### **Final Report - Corrections Required** **Application No. ANEX-24-0005**

**Description : Matrix Design Group on behalf of Colorado Springs Equities LLC is submitting a serial annexation petition for seven parcels and Land Use Plan/Rezoning exhibit for a portion of the subdivision known as Rock Creek Mesa.**

**Document Filename : 224.023-SURV-RCM ANNEX PLAT 5.pdf**

ROCK CREEK MESA ADDITION NO. 5

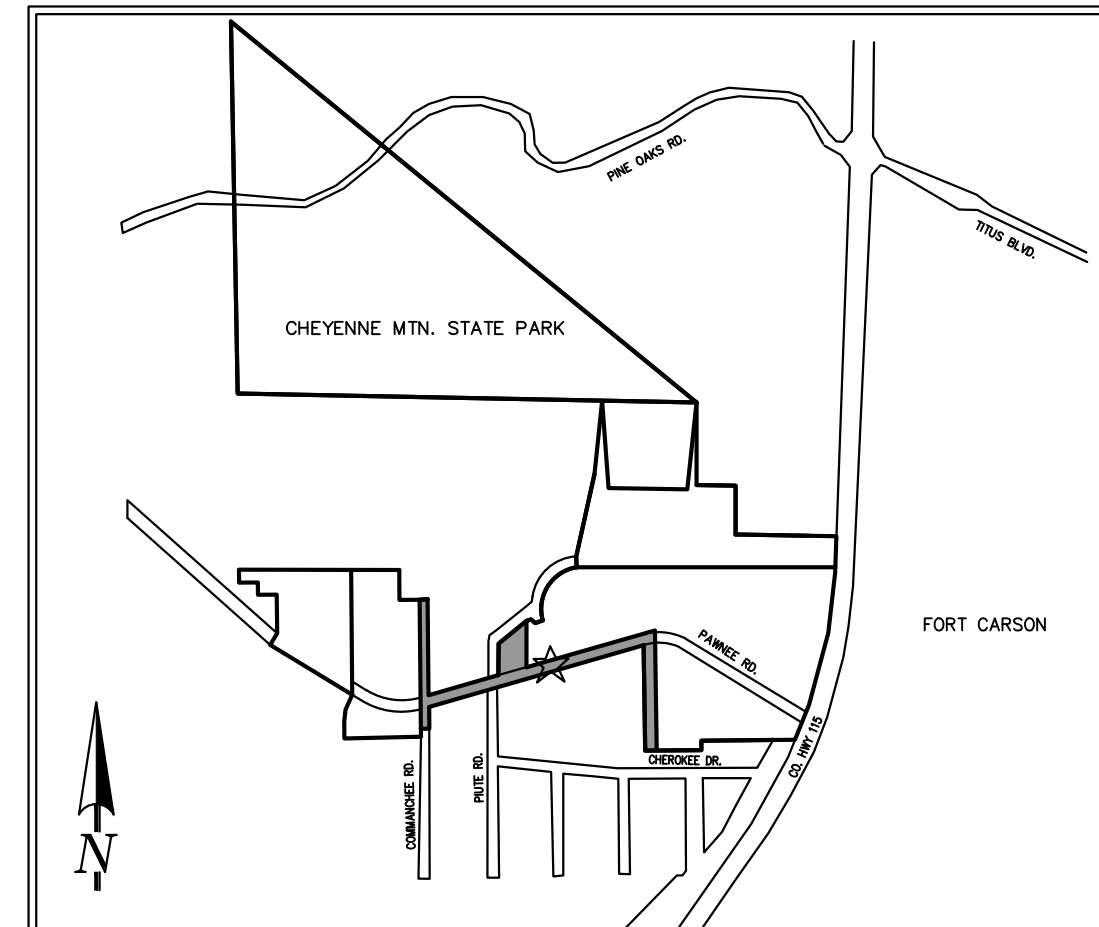
14	224.023-SURV-RCM ANNEX PLAT 5-TITLE	Sara Rivera : City Engineering - SWENT	The FEMA floodplain zone is incorrect. Please update to the correct zone.
2	224.023-SURV-RCM ANNEX PLAT 5-TITLE	Matthew Alcuran : Col Springs Utilities	<p>Please acknowledge the following Water Planning Informational Note: Please refer to the completed Hydraulic Analysis Report completed on November 2, 2023 for HR Green and SSS Education. Conclusions and Requirements: **Modeled fire flows are 2100 to 2200 GPM. No fire flow requirement was provided. **Either alternative presented in this report are acceptable. **Since all pressures are below 170 psi, PVC is acceptable.</p>
3		Matthew Alcuran : Col Springs	Utility Comments (electric, gas, water, wastewater)

8	224.023-SURV-RCM ANNEX PLAT 5-TITLE	Matthew Alcuran : Col Springs Utilities	<p>Please response to CSU LBS comments: Have reviewed and entered geometry into FIMS.</p> <p>"Please add detail to the Point of Beginning, as it is not on the eastern ROW line of Commanche Rd."</p> <p>"The course N 73 ° 41' 01" E 609.15 FEET in the written legal is shown as N 73 ° 41' 05" E on the graphic."</p>
18	224.023-SURV-RCM ANNEX PLAT 5-TITLE	Gabe Sevigny : Planning	Update to ANEX-24-0005 to each sheet
19	224.023-SURV-RCM ANNEX PLAT 5-TITLE	Cory Sharp : Planning	Please add the area at the end of the legal description
20	224.023-SURV-RCM ANNEX PLAT 5-TITLE	Cory Sharp : Planning	N73-41-05 E closure
21	224.023-SURV-RCM ANNEX PLAT 5-TITLE	Cory Sharp : Planning	N90-00-00W closure
22	224.023-SURV-RCM ANNEX PLAT 5-TITLE	Cory Sharp : Planning	<p>Please update 3, 4 &amp; 5 to the following contiguity statement:</p> <p>contiguity statement:</p> <p>Total Perimeter of the Area for Annexation: 5,680.60' One-Fourth (1/4th) of the Total Perimeter: 1,420.15' (25.00%) Perimeter of the Area Contiguous to the Existing City Limits: 1,582.49' (27.86%)</p>

ROCK CREEK MESA ADDITION NO. 5

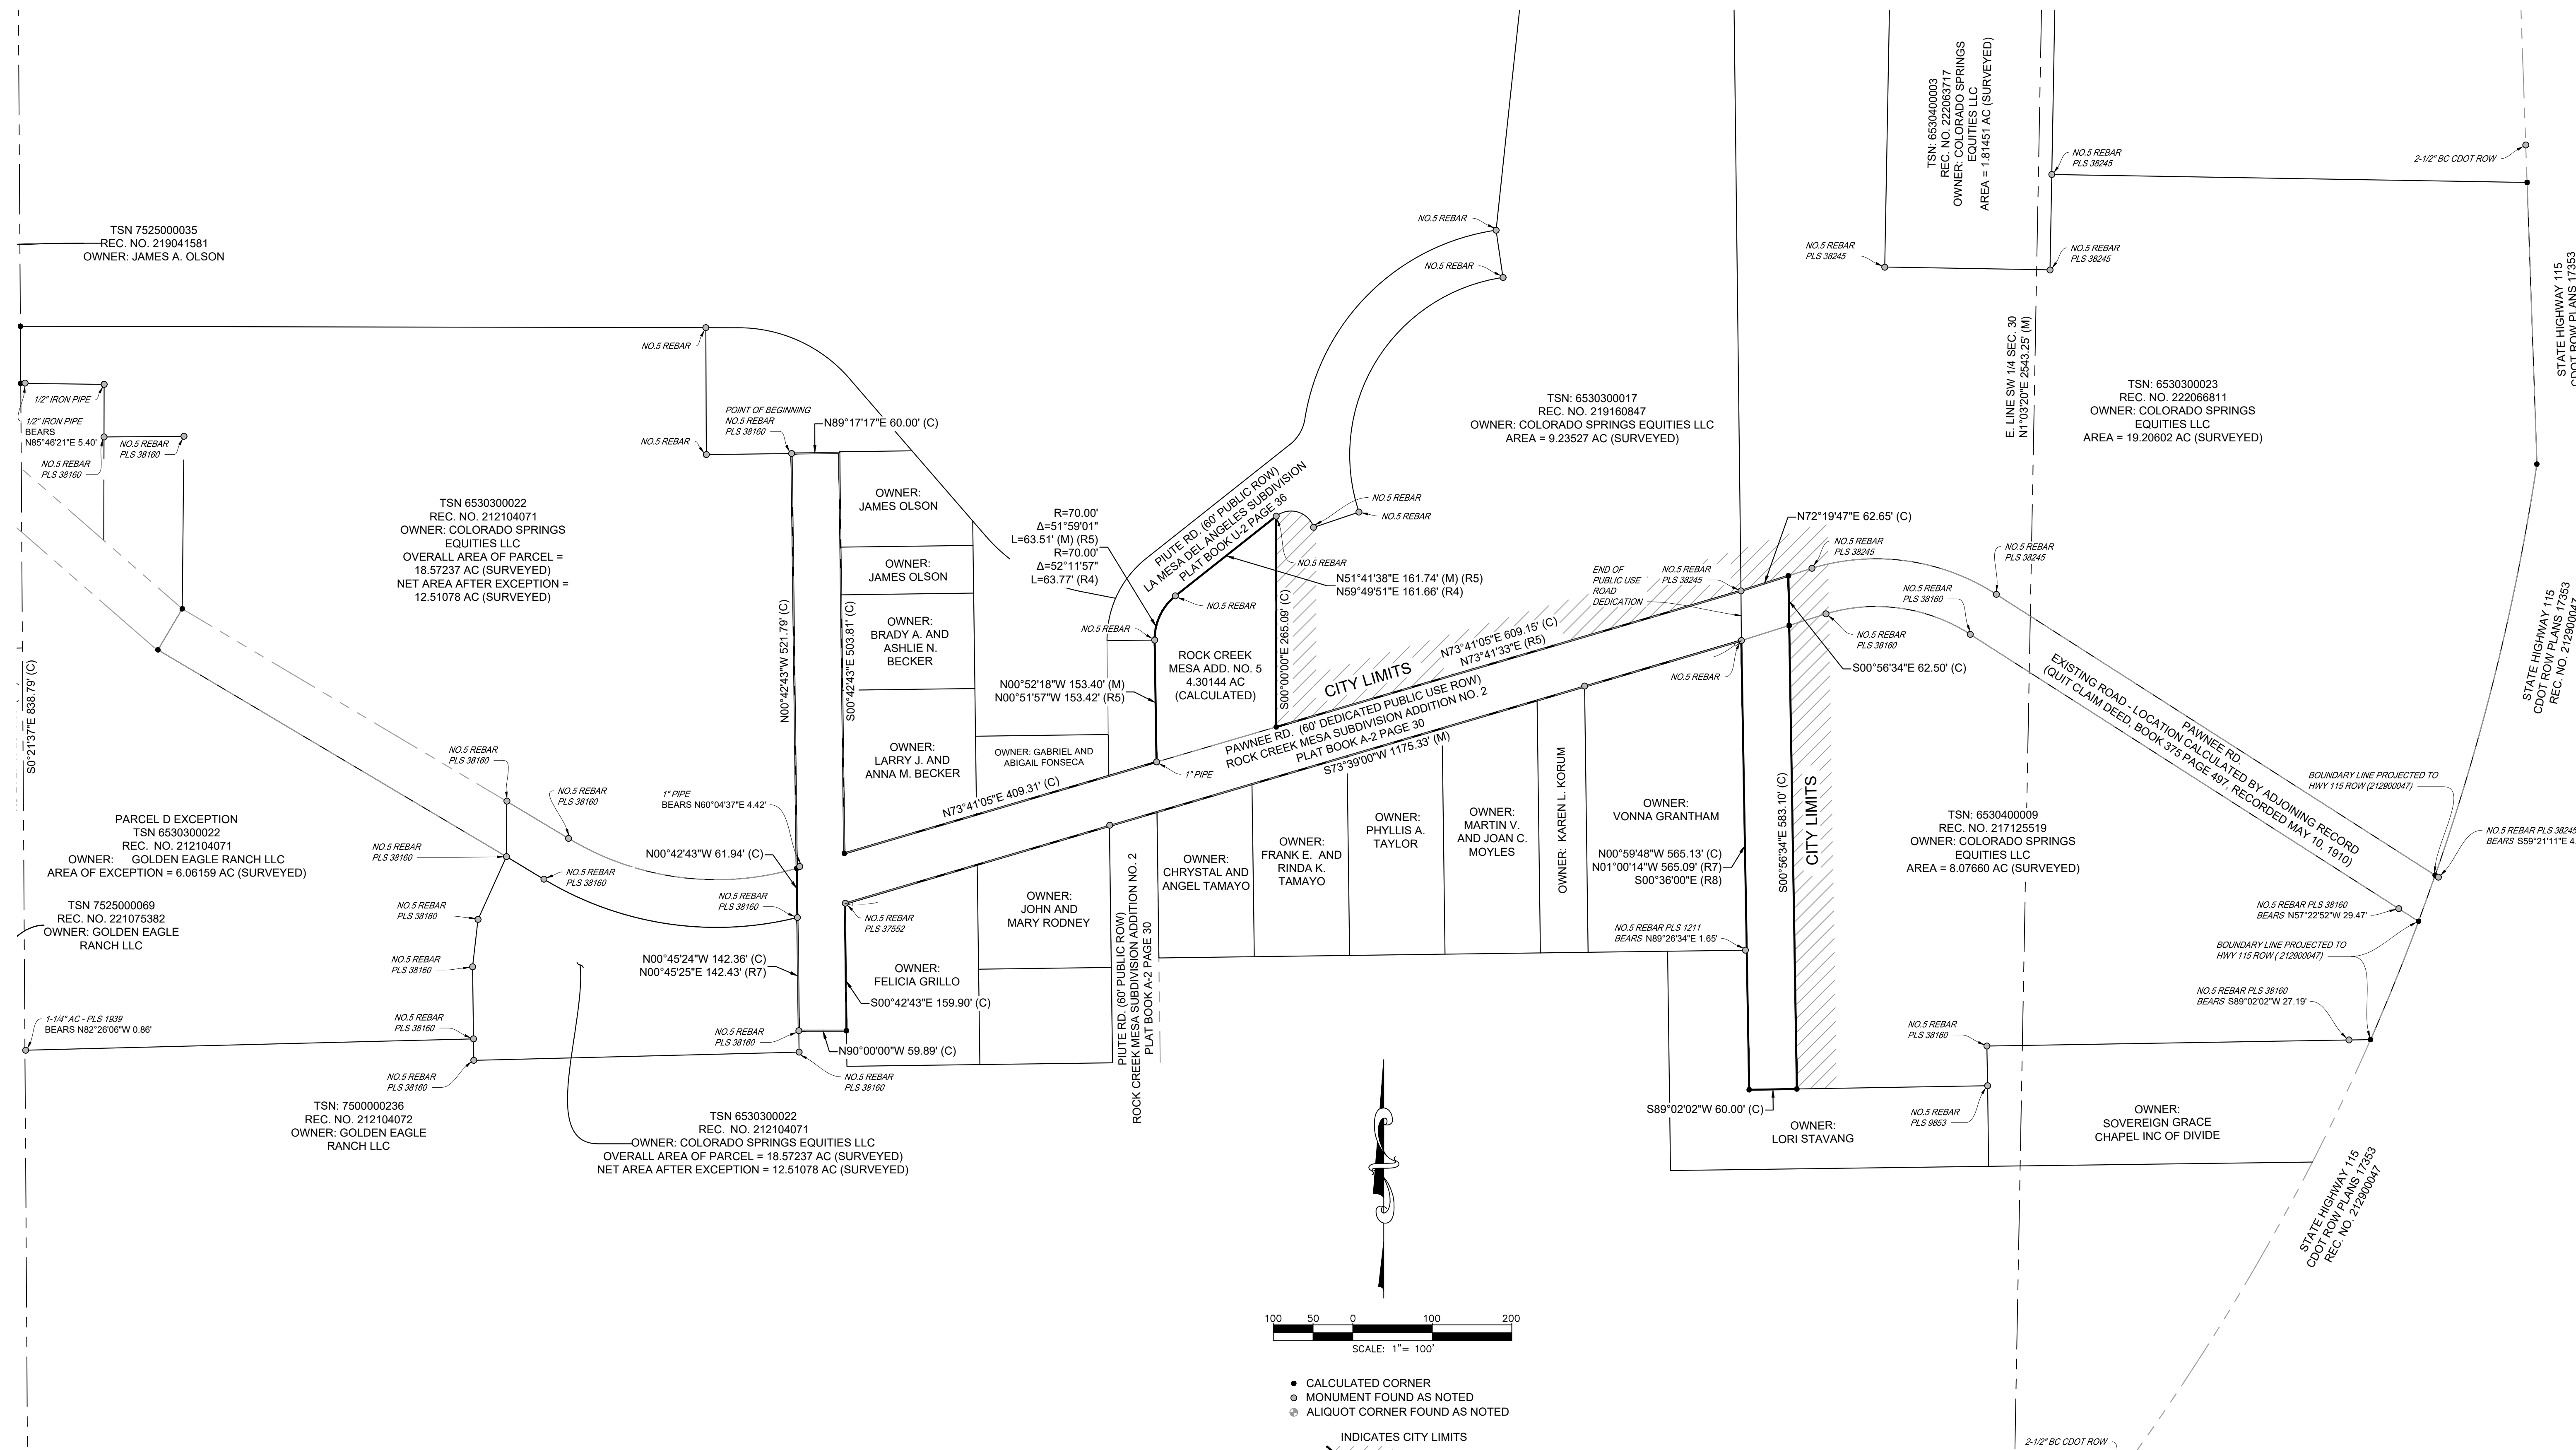
23	224.023-SURV-RCM ANNEX PLAT 5-TITLE	Cory Sharp : Planning	Please add quotations around the plat name "Rock Creek Mesa Addition No. 5"
24	224.023-SURV-RCM ANNEX PLAT 5-GRAPHIC 1	Cory Sharp : Planning	This portion of roadway still in question see Addition No. 4 comments

<b>Comment ID</b>	<b>Page Reference</b>	<b>Reviewer : Department</b>	<b>Review Comments</b>
25	224.023-SURV-RCM ANNEX PLAT 5-GRAPHIC 1	Cory Sharp : Planning	Please label the prior Rock Creek Mesa Additions
26	224.023-SURV-RCM ANNEX PLAT 5-GRAPHIC 1	Cory Sharp : Planning	Please clearly depict all of the city limits not just that adjacent portion
27	224.023-SURV-RCM ANNEX PLAT 5-GRAPHIC 1	Cory Sharp : Planning	Please remove the areas from all adjacent parcels
28	224.023-SURV-RCM ANNEX PLAT 5-GRAPHIC 1	Cory Sharp : Planning	Please clearly label the adjacent areas *not a part* for clarity
29	224.023-SURV-RCM ANNEX PLAT 5-GRAPHIC 1	Cory Sharp : Planning	It would be easier for review if the adjacent areas were a dashed line type, please review and adjust accordingly
30	224.023-SURV-RCM ANNEX PLAT 5-GRAPHIC 1	Cory Sharp : Planning	It would be helpful to change the text style of ownership information so that is clearly informational text

31	224.023-SURV-RCM ANNEX PLAT 5-GRAPHIC 1	Cory Sharp : Planning	Please remove Rock Creek Mesa Addition No. 5
32	224.023-SURV-RCM ANNEX PLAT 5-GRAPHIC 1	Cory Sharp : Planning	Please add (M) and (C) to the legend
33	224.023-SURV-RCM ANNEX PLAT 5-GRAPHIC 1	Cory Sharp : Planning	Why are the right-of-way lines not parallel?
34	224.023-SURV-RCM ANNEX PLAT 5-GRAPHIC 1	Cory Sharp : Planning	Please depict and label the basis of bearings and add tie to point of beginning so all additions can be tied together
35	224.023-SURV-RCM ANNEX PLAT 5-GRAPHIC 1	Cory Sharp : Planning	Why did the point of beginning jump to a location that is not tied to addition no. 4? It would be more helpful if the point of beginning was common to previous addition

Why did the point of beginning jump to a location that is not tied to addition no. 4? It would be more helpful if the point of beginning was common to previous addition

Please depict and label the basis of bearings and add tie to point of beginning so all additions can be tied together

Please remove Rock Creek Mesa Addition No. 5

It would be helpful to change the text style of ownership information so that is clearly informational text

This portion of roadway still in question see Addition No. 4 comments

Why are the right-of-way lines not parallel?

Please add (M) and (C) to the legend
